Response to Planning application from Hertfordshire County Council (T and CP GDP Order 2015)

District ref: 6/2024/1162/COND
HCC ref: WH/21478/2024
HCC received: 1 July 2024
Area manager: Manjinder Sehmi
Case officer: Shamsul Huda

29 Broadwater Road Welwyn Garden City Hertfordshire AL7 3BQ

Submission of details pursuant of conditions 1 and 24 (Construction Management Plan) on planning permission 6/2019/3024/MAJ

Copyright © 2024

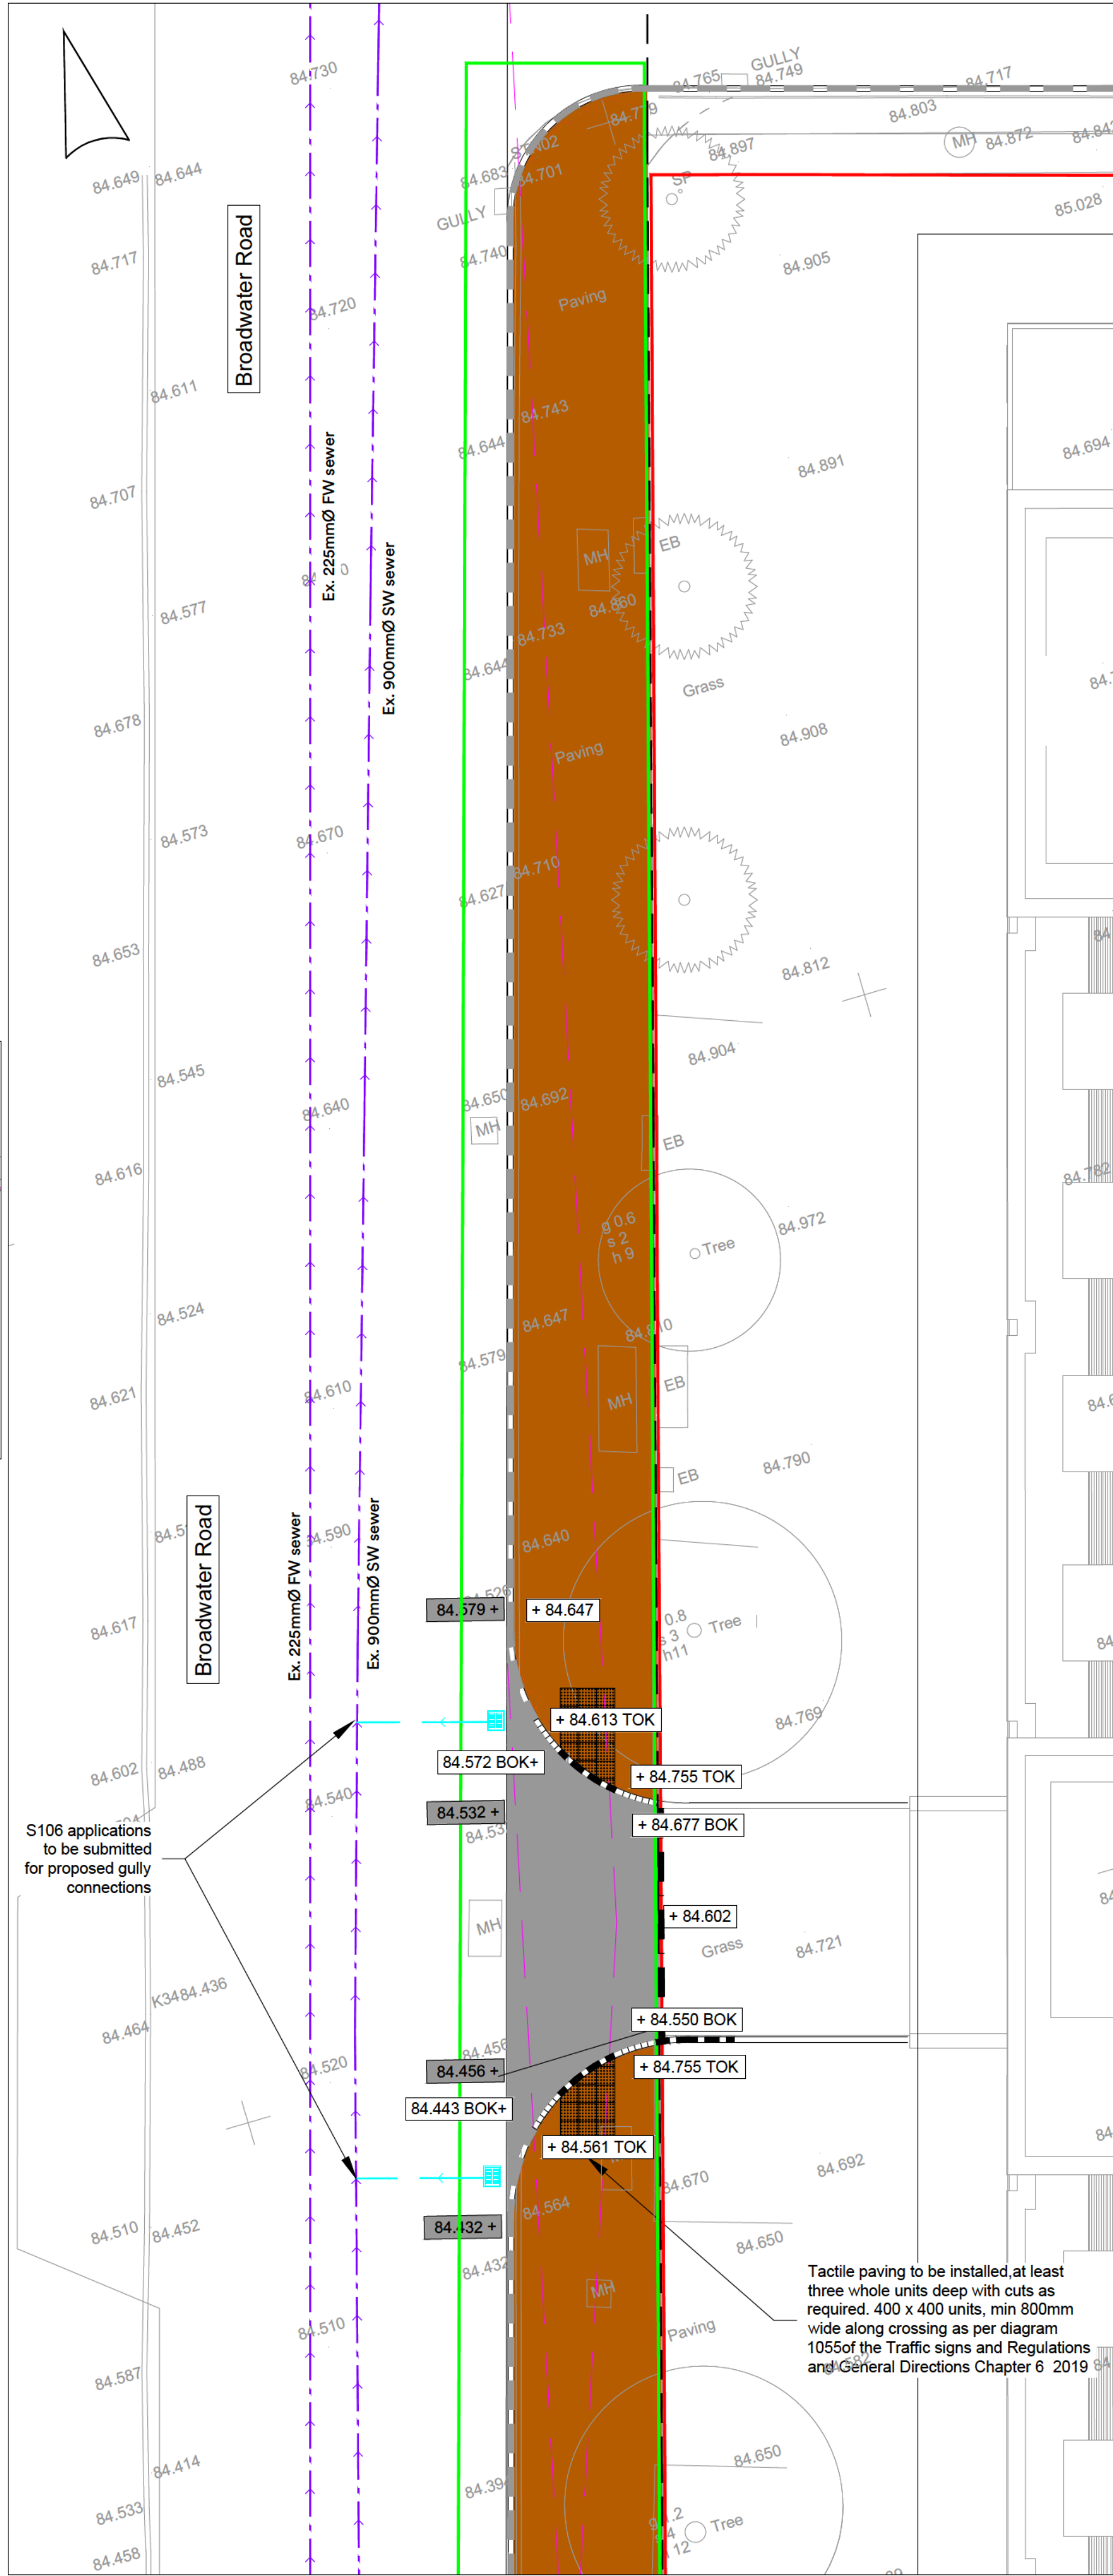
It shows that the submitted CMP includes incorrect context of s278 works. Two site access points off Broadwater Road are included in the appendix E, which shows the scope of the s278 works, in conflict to the planning requirements 14 and 15. In accordance with condition 15, only the central access (main access) shall be allowed to access the site; all other access points, including the south entrance, should be permanently closed off Broadwater Road .

Thus, it is recommended that the applicant submit the CMP again together with the accurate scope of the S278 works.
